Your Ref: OWPC16246
Our Ref: FG/172/17/HH 03-11-2017
Please ask for:
Mark Jones

Single storey rear extension.
5 Sark Gardens Ferring

PROPOSED ELEVATIONS 1:100@A3

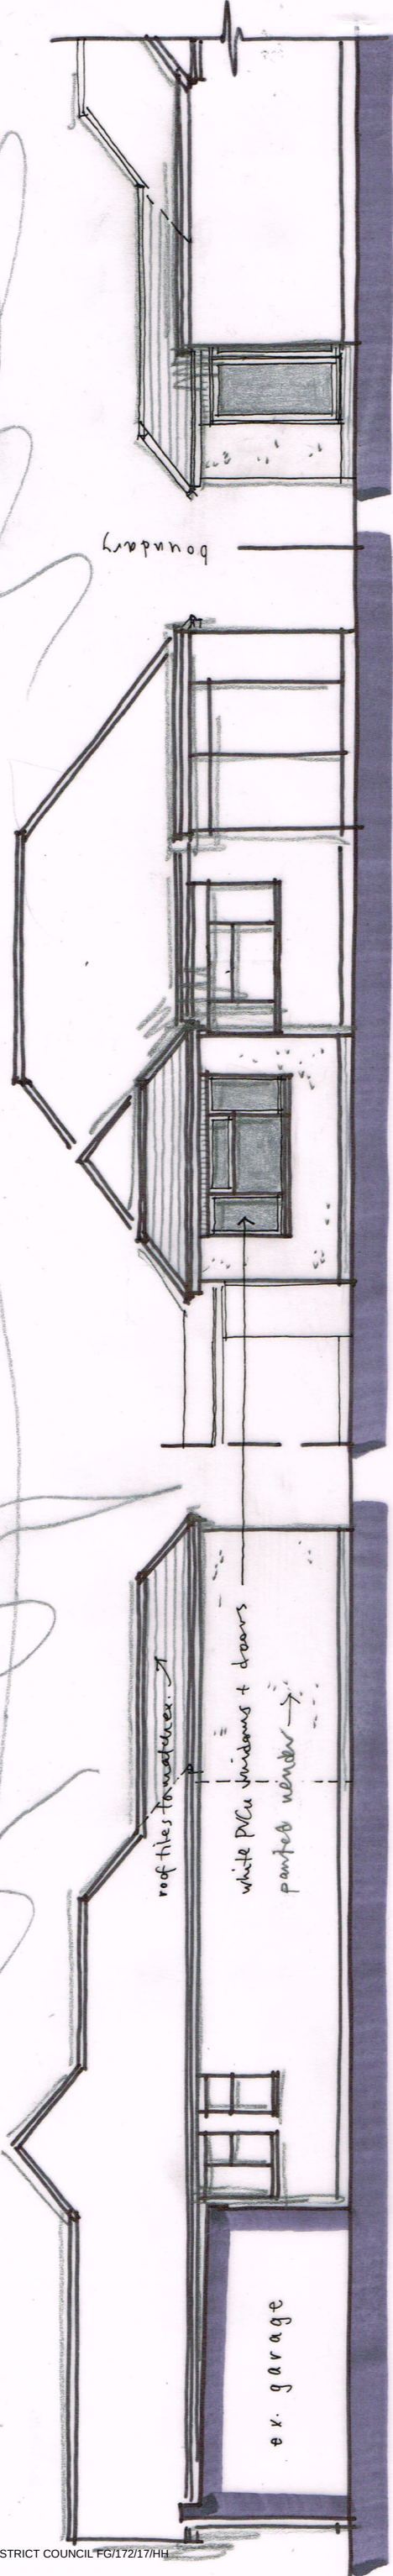
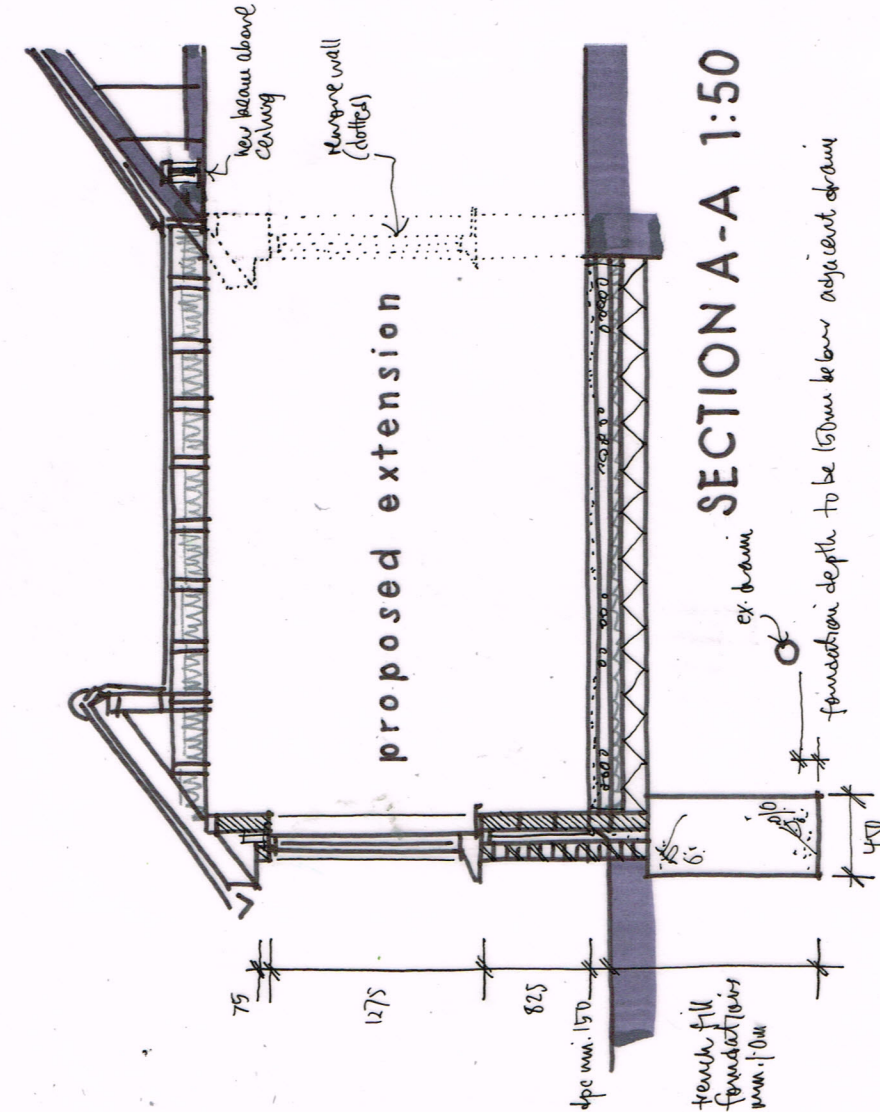
- 1 There are no bedrooms shown on the plan. I am led to believe there are four.*
- 2. The plans seem to indicate that the drains are to be covered and not moved.*
- 3. The rendering has been actioned and is not in keeping with the adjacent properties.*
- 4. To date there is no yellow application on view*
